**Subject: Century Tire Plaza – 195 Kennebec Street
Project ID# 2015-027
Review Comments Received May 7, 2015**

We have received and reviewed the City's review comments and offer our responses to these comments. For ease of reference we have repeated each comment in *italics* with our response following.

E100

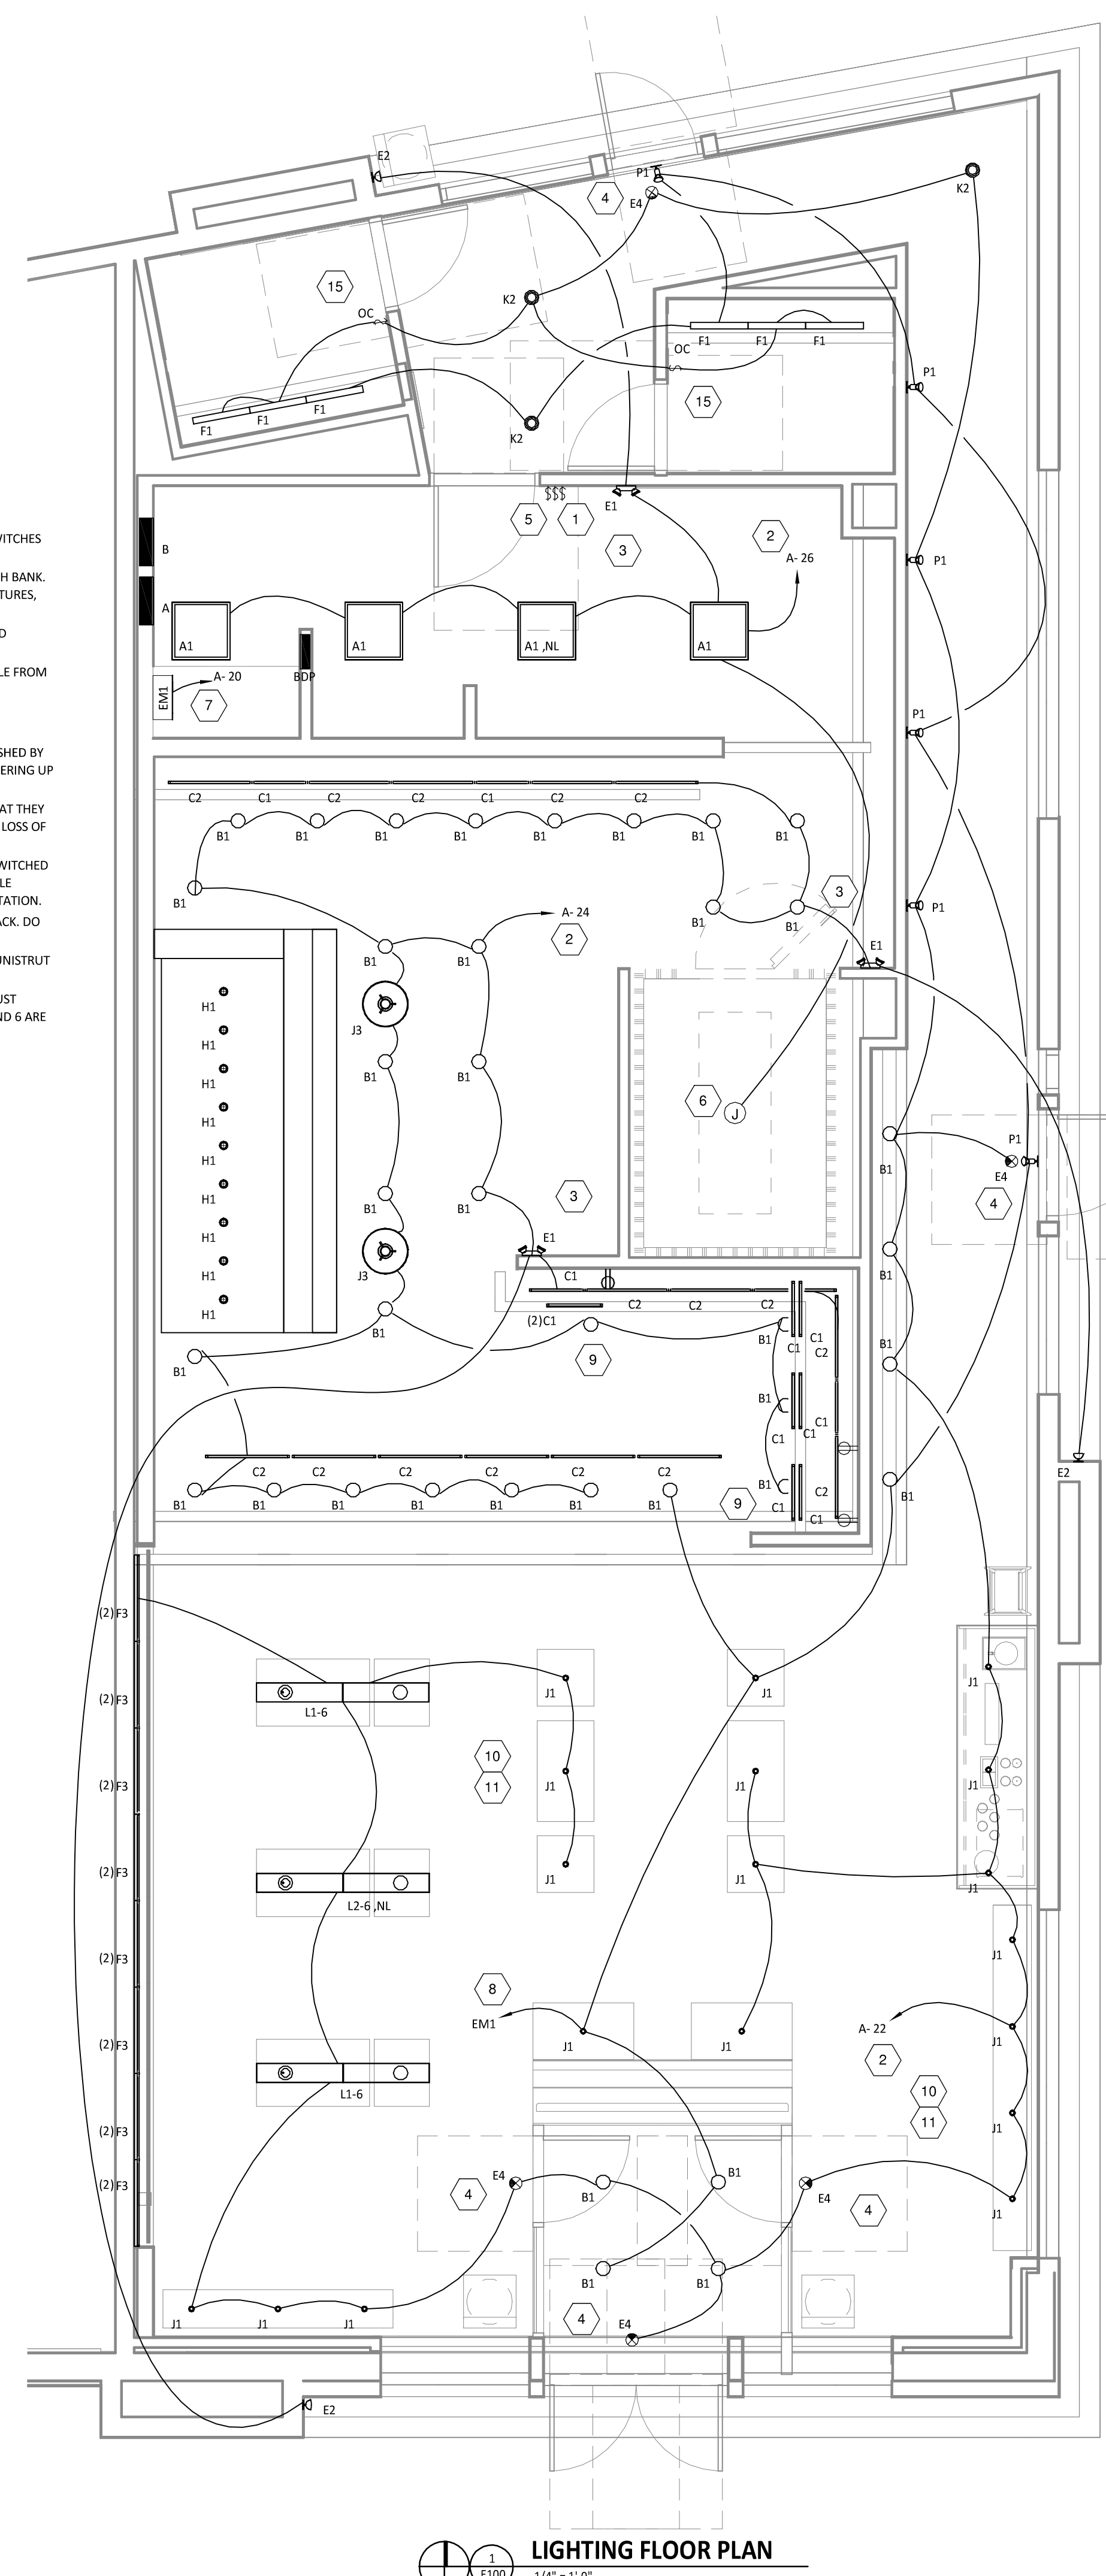
- 1. On Marginal Way, where does the proposed electrical conduit connect to the existing lighting circuit? Show the location and details of the connection. Show the location of the conduit to be installed.*

- 2. On Kennebec Street, show connection from the proposed meter to the utility power grid. Show the electrical panel design details.*
- 3. Specify the conduit size, type, and provide installation detail showing the depth of cover (minimum of 36"), conduit encasement, and marker tape.*

- 4. Specify and show the conduit location with respect to right of way or some other reference.*
- 5. Are light fixtures, poles, and pole foundations details provided?*

- 6. The applicant will be responsible for all connections, wiring and any other ancillary work required for a complete street project. Please delete reference that the City is responsible for such work.*

- 7. It is understood that all street lighting will have LED fixtures, all circuits metered for City billing and please not that a 120v outlet per pole is not required*

Please see revised electrical plan from Bennett Engineering that addresses these comments.
